Oulton Parish Council (OPC) have recently sent in comments in regard to the **‘Response to Secretary of State Letter dated 9 July 2021 - Updated information on cumulative and in combination effects with the Dudgeon and Sheringham Shoal Extension Projects’** this was sent on 10th September 2021 and accepted on the 23rd September.

OPC would therefore like the opportunity to highlight some further issues from the **cumulative impact** document.....

Figure: 25.2a		Drawing No: PB5640-006-025-002a			
Revision:	Date:	Drawn:	Checked:	Size:	Scale:
02	05/03/2019	JT	CD	A3	1:25,000
01	01/03/2019	JT	CD	A3	1:25,000

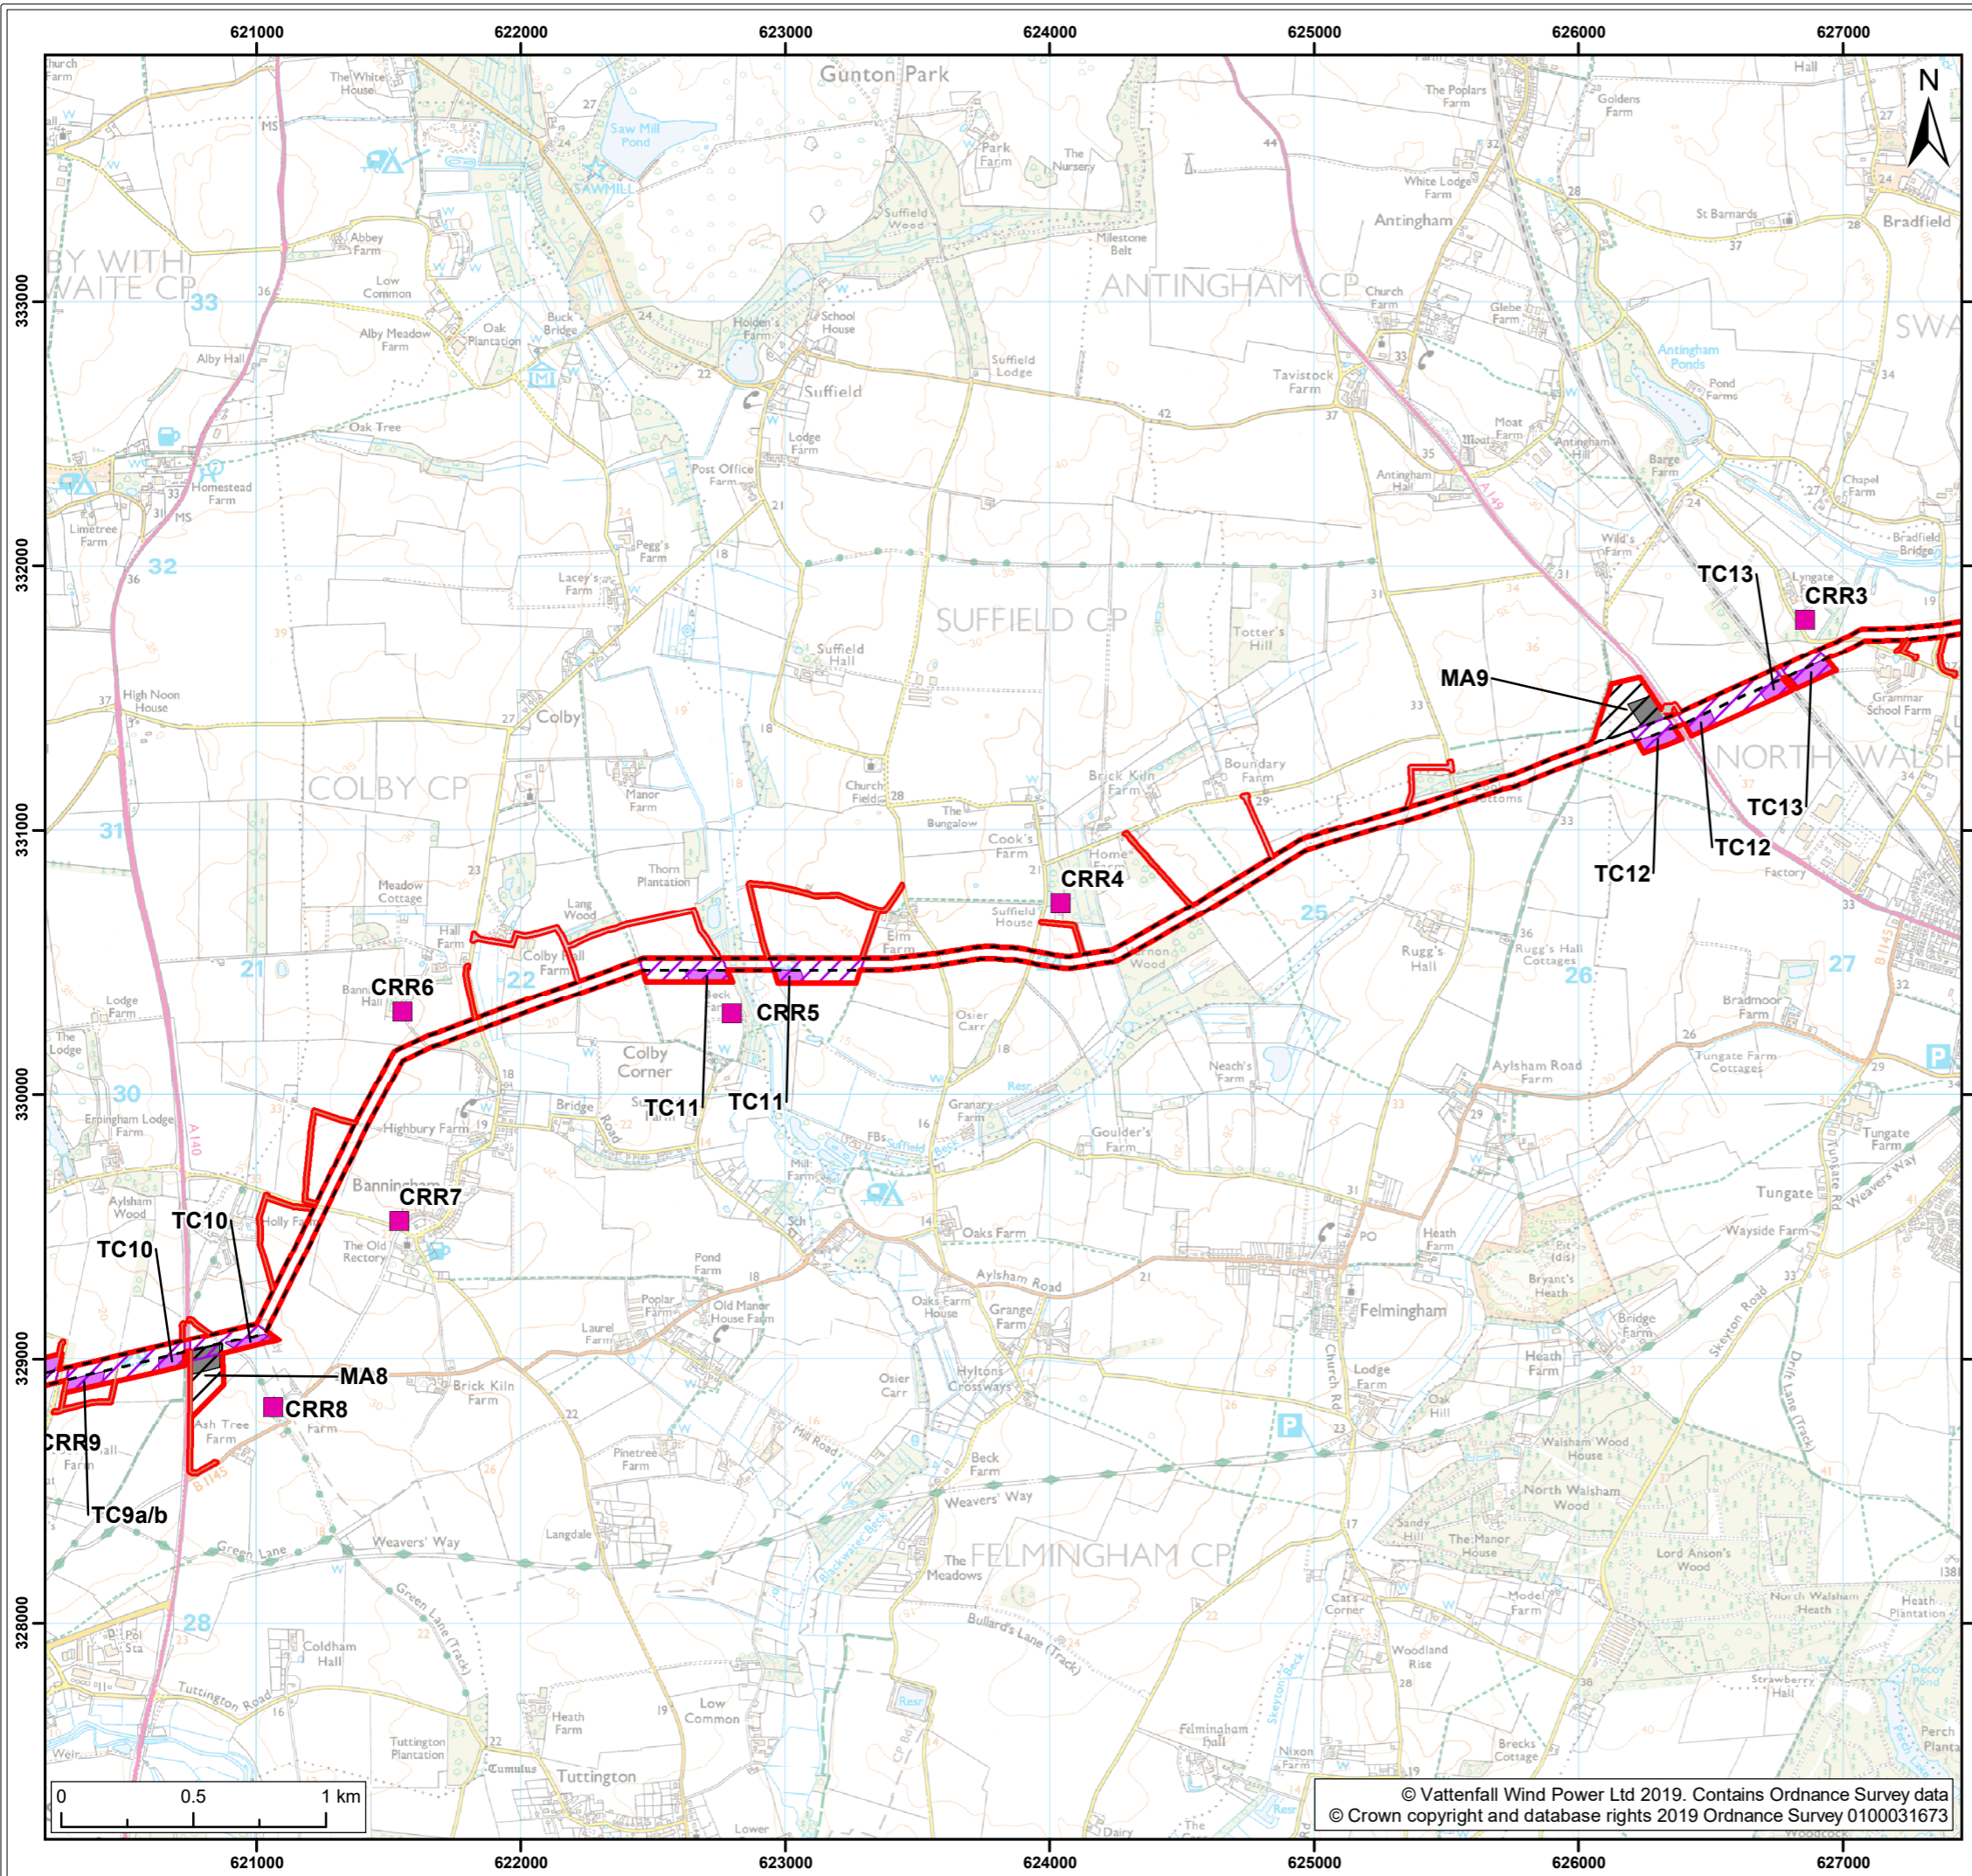
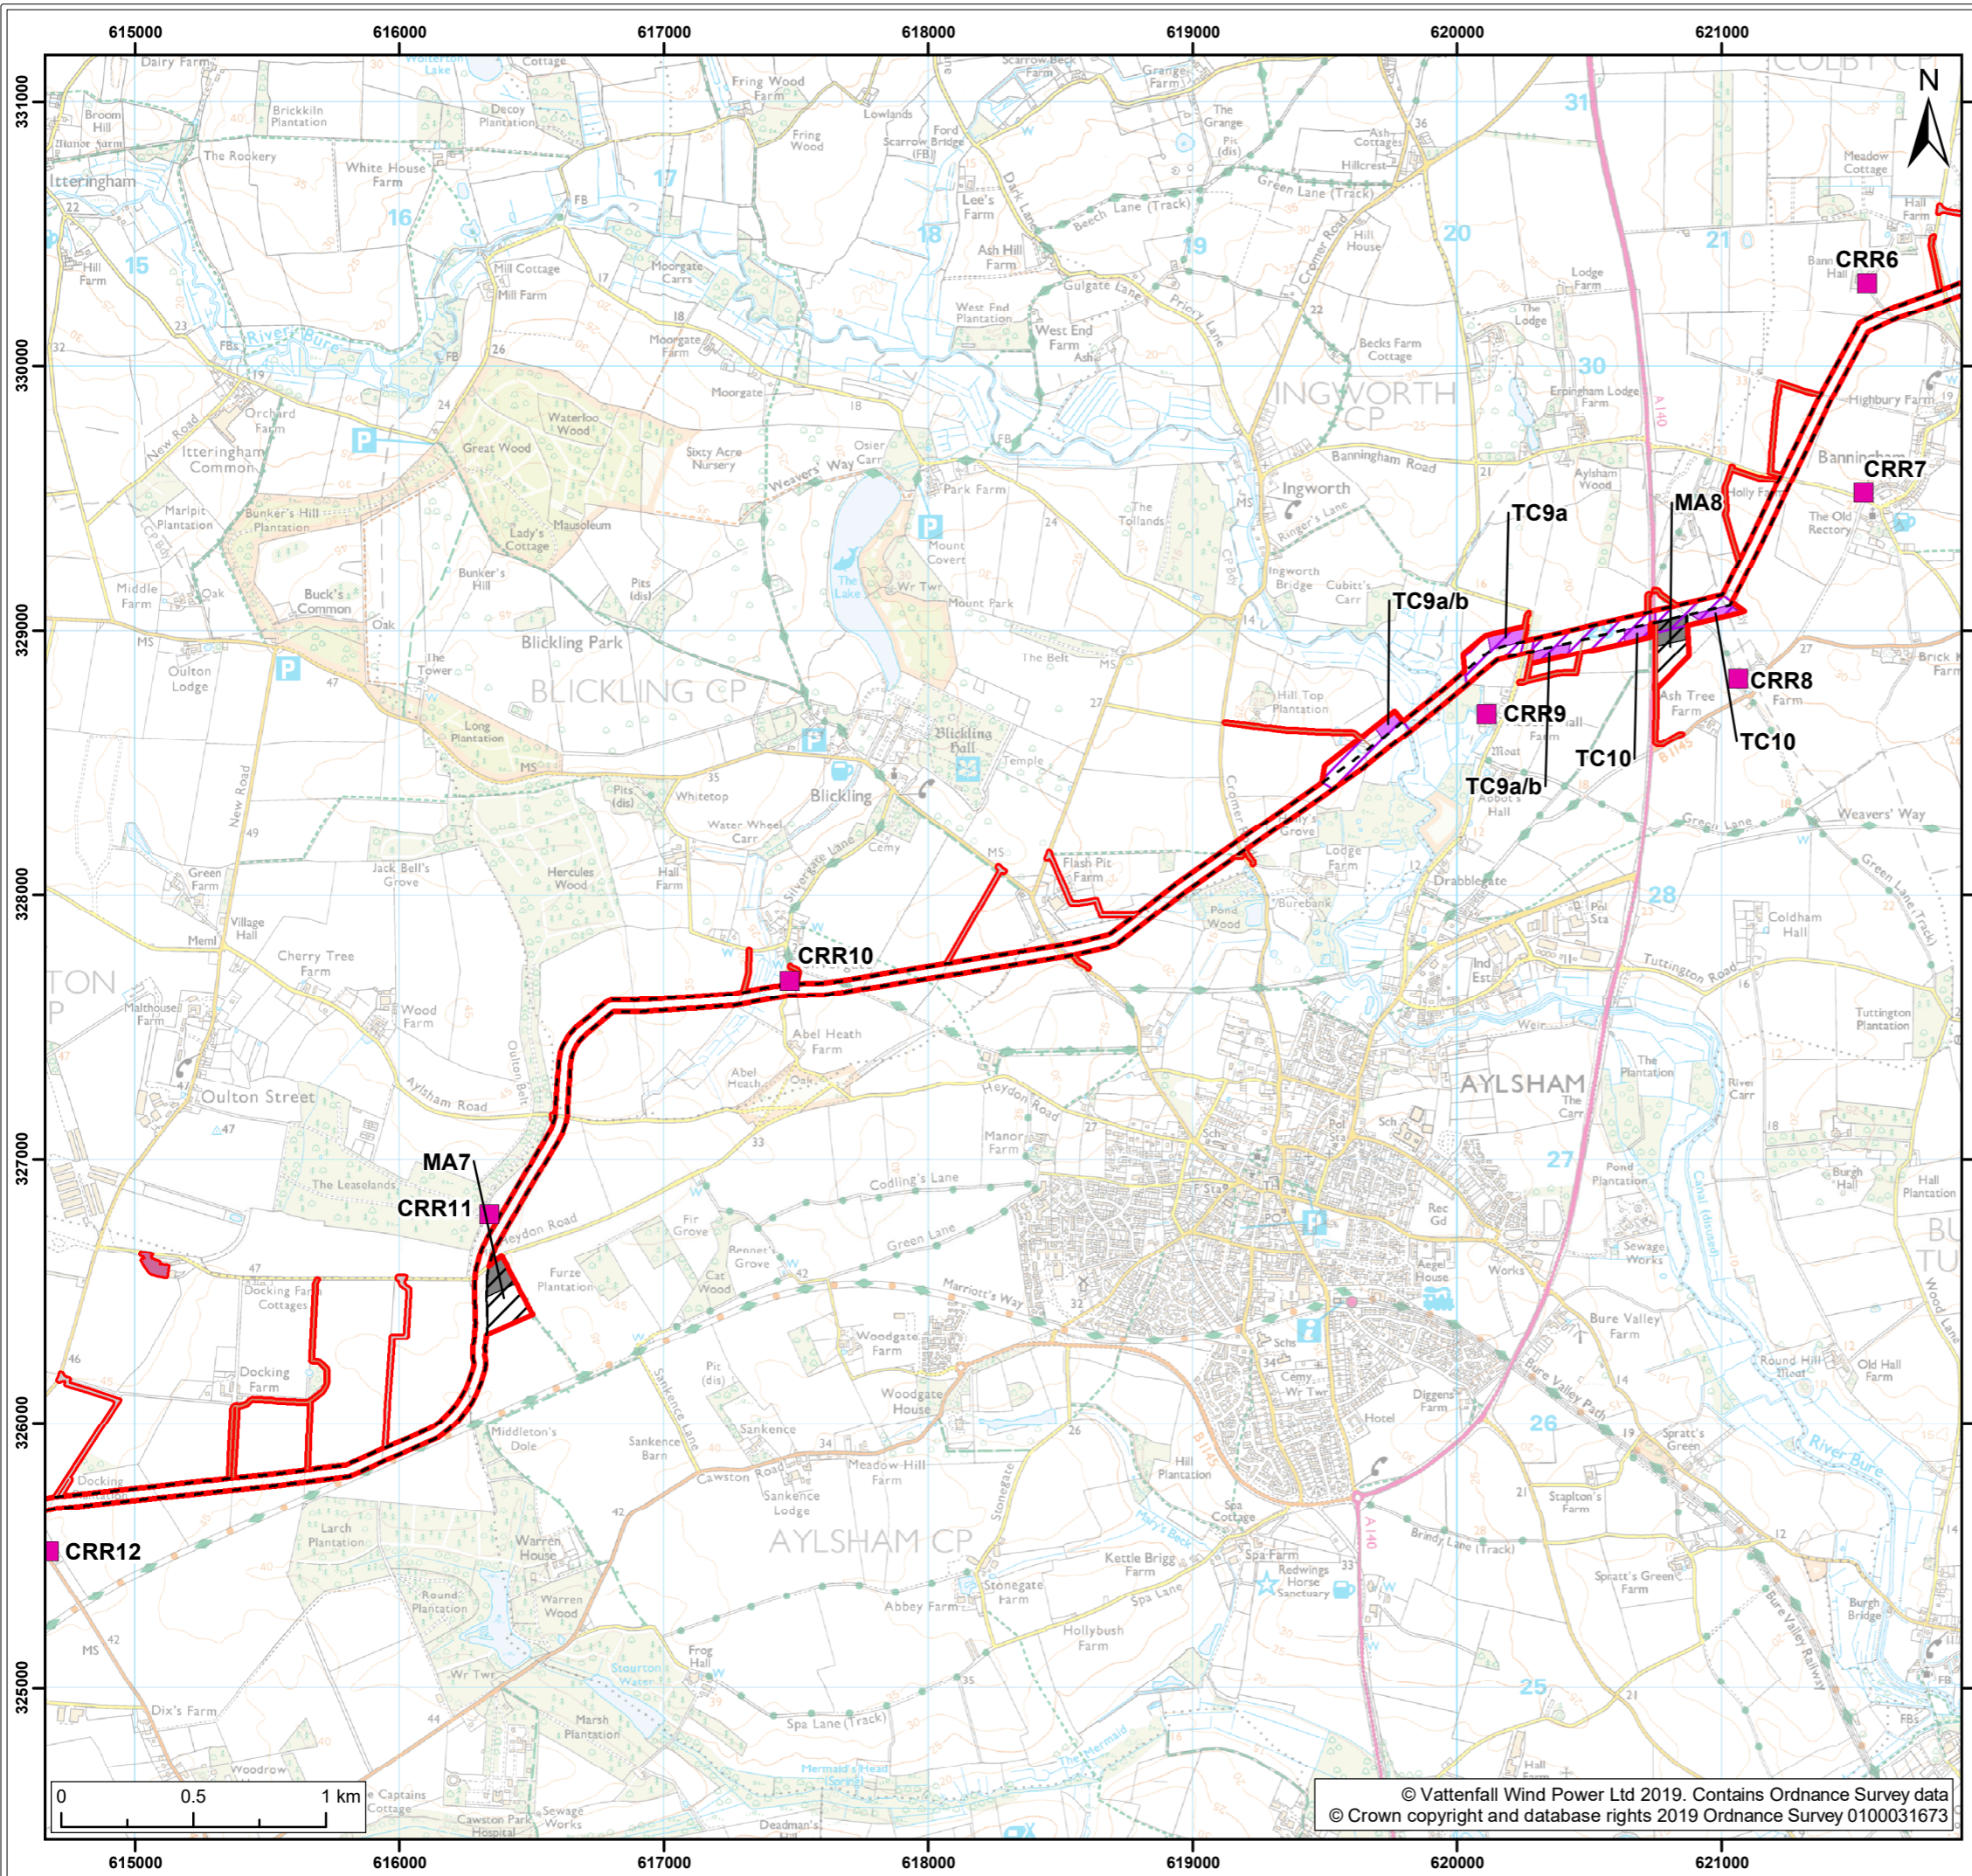
The proposed DEP and SEP onshore cable route would cross the Norfolk Boreas cable route east of Cawston. There is a common noise sensitive receptor in proximity to both projects (CRR12 as shown on Figure 25.2 of ES chapter 25 Noise and Vibration [APP-470]). Construction noise at CRR12 for Norfolk Boreas was assessed as no impact during the peak construction phase (2023/2024). The DEP and SEP cumulative impact assessment concluded that there would be no cumulative construction noise impacts with Norfolk Boreas.

It should be noted that there will be additional noise at this **sensitive receptor (CRR12)** as there will be the need for a HDD crossing of the B1149 at this point, for Norfolk Boreas Scenario 2. This has been excluded from the cumulative impact. This would also apply to DEP/SEP.
